City of Albuquerque

**RE: Grading and Drainage Plan for Seavey - Journal Center, Tract A1-2-A-2,
Journal Center, (D-17/D003V2), Engineer stamp dated 7/20/01.**

**RE: Grading and Drainage Plan for Seavey - Journal Center, Tract A1-2-A-2,
Journal Center, (D-17/D003V2), Engineer stamp dated 6/25/01.**

**C3.0**

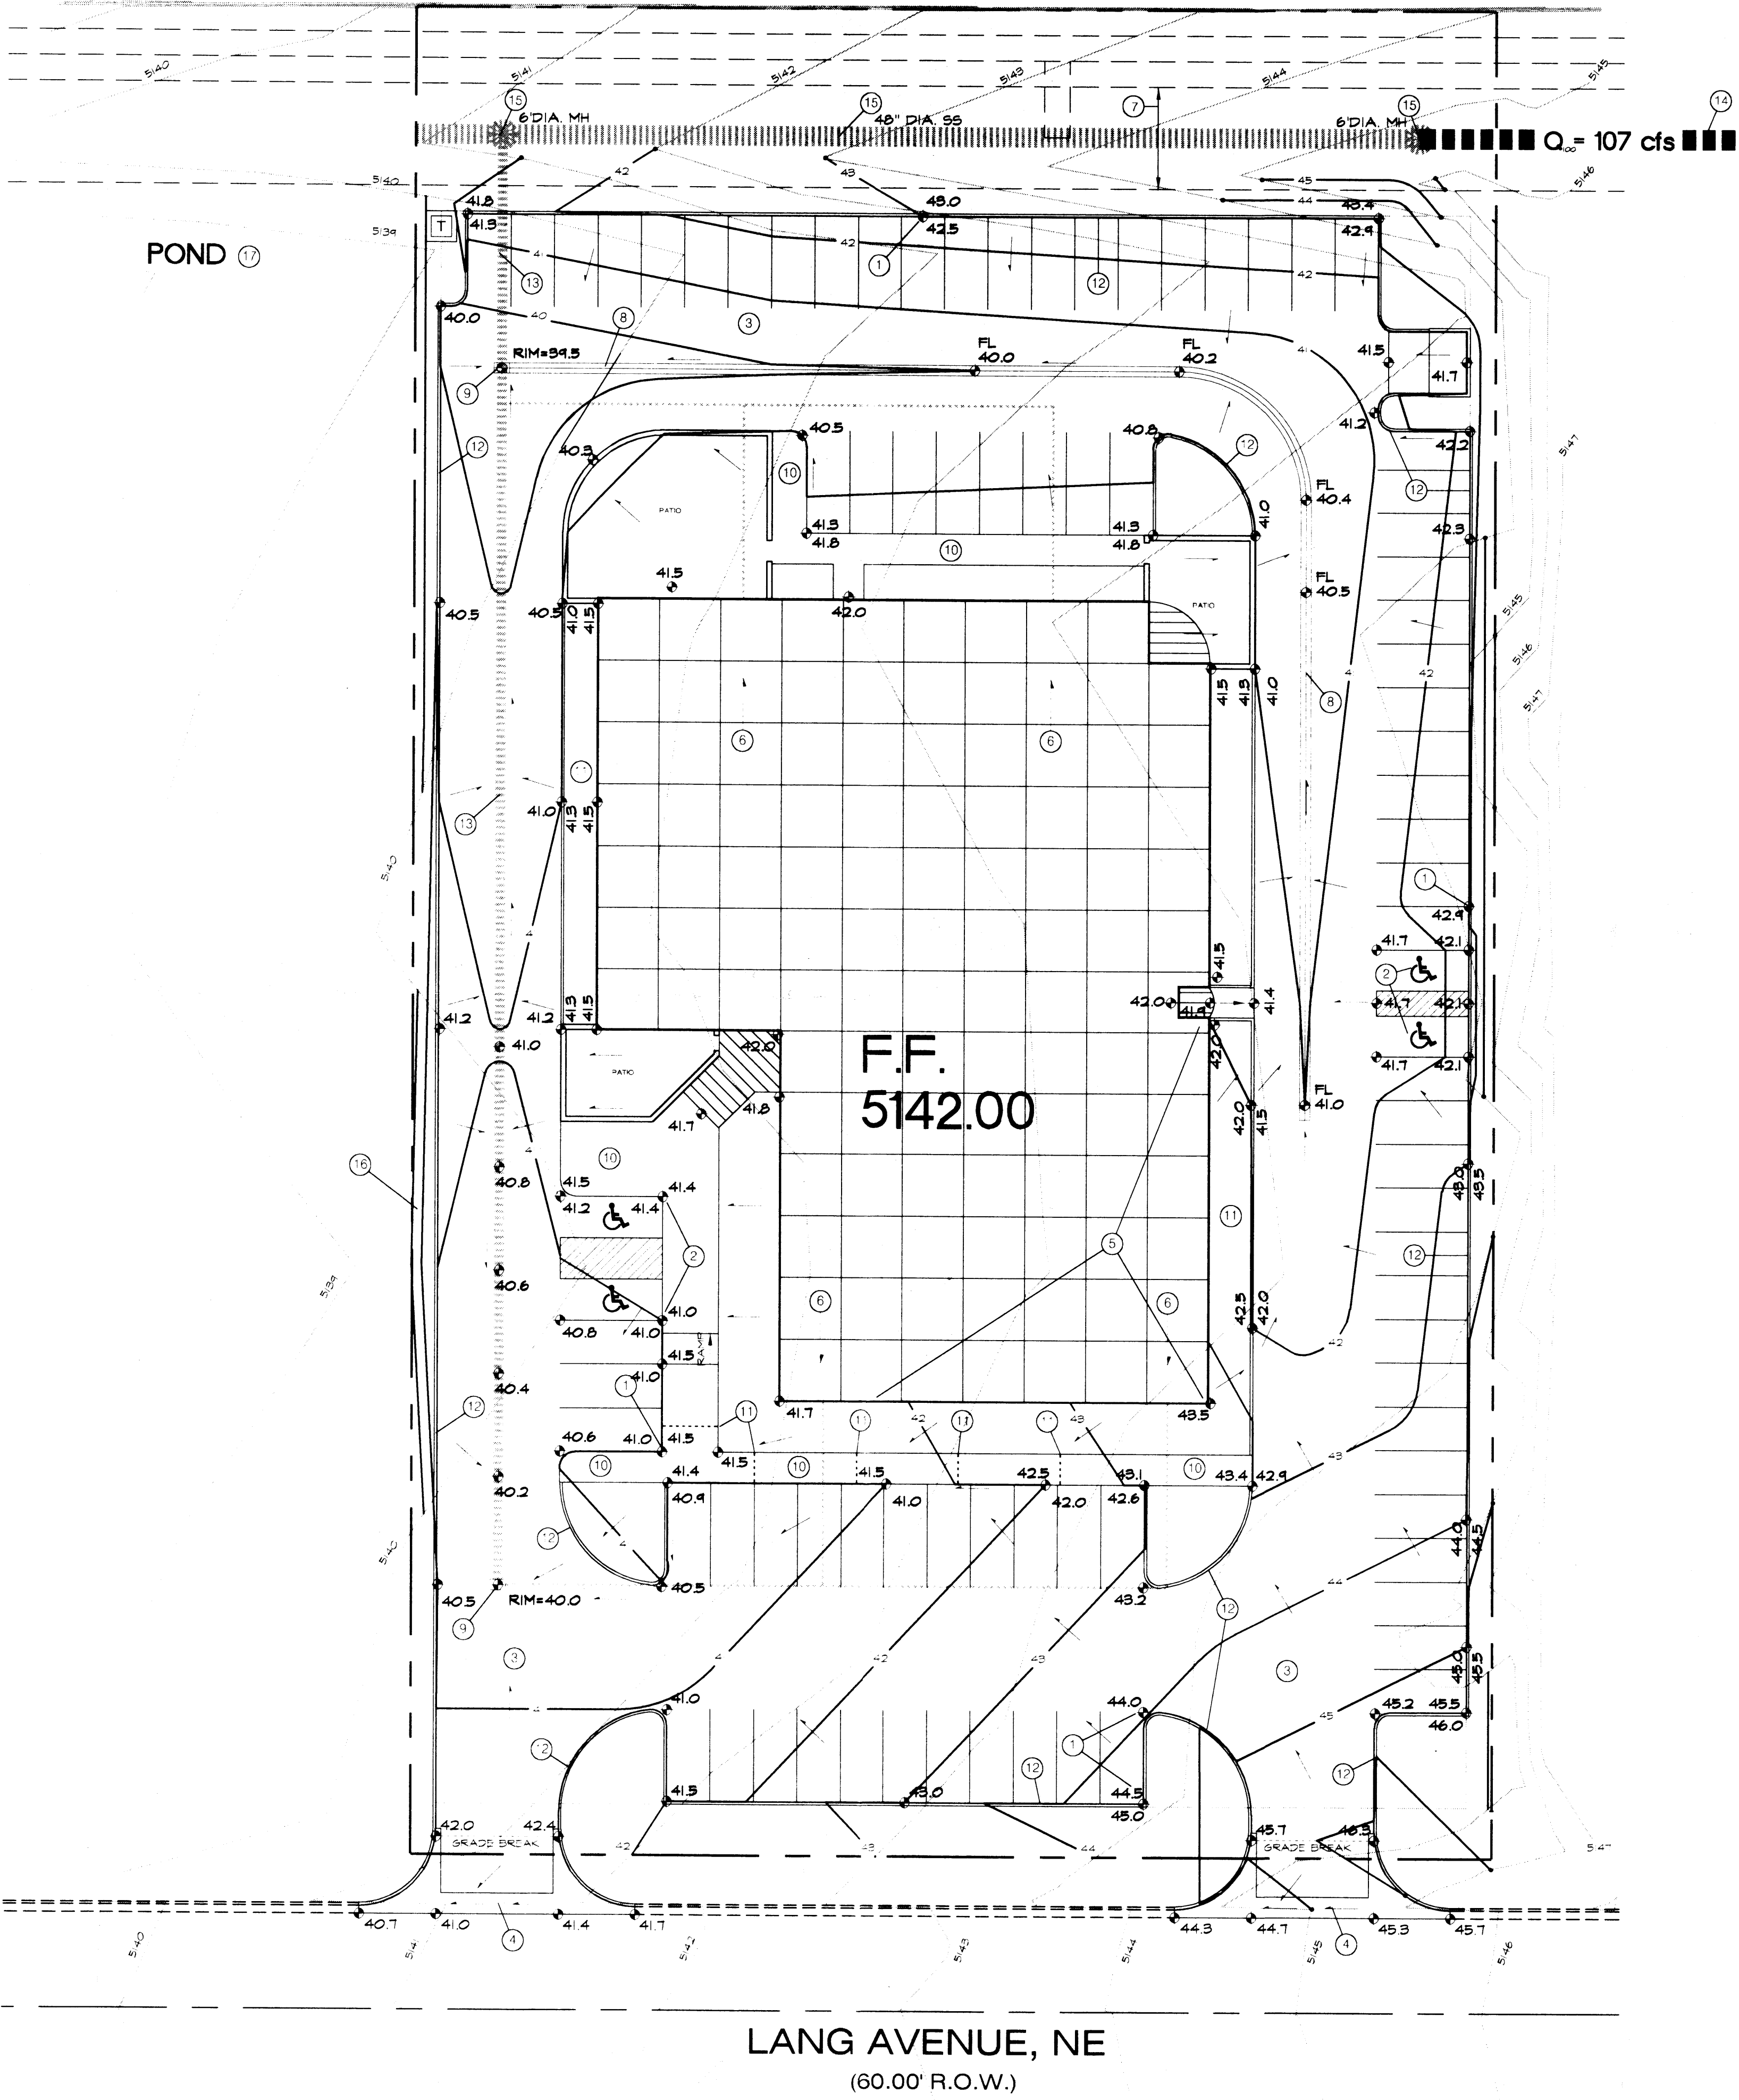
1. On note 15, remove the pipe produce manufacturer name. The pipe product should specify HDPE smooth-flow pipe with rubber gasket bell and spigot joints, conforming to NMSHTD standard specifications.
2. Install a 6' dia. Std city manhole at the junction of the 24" and 48" pipes.
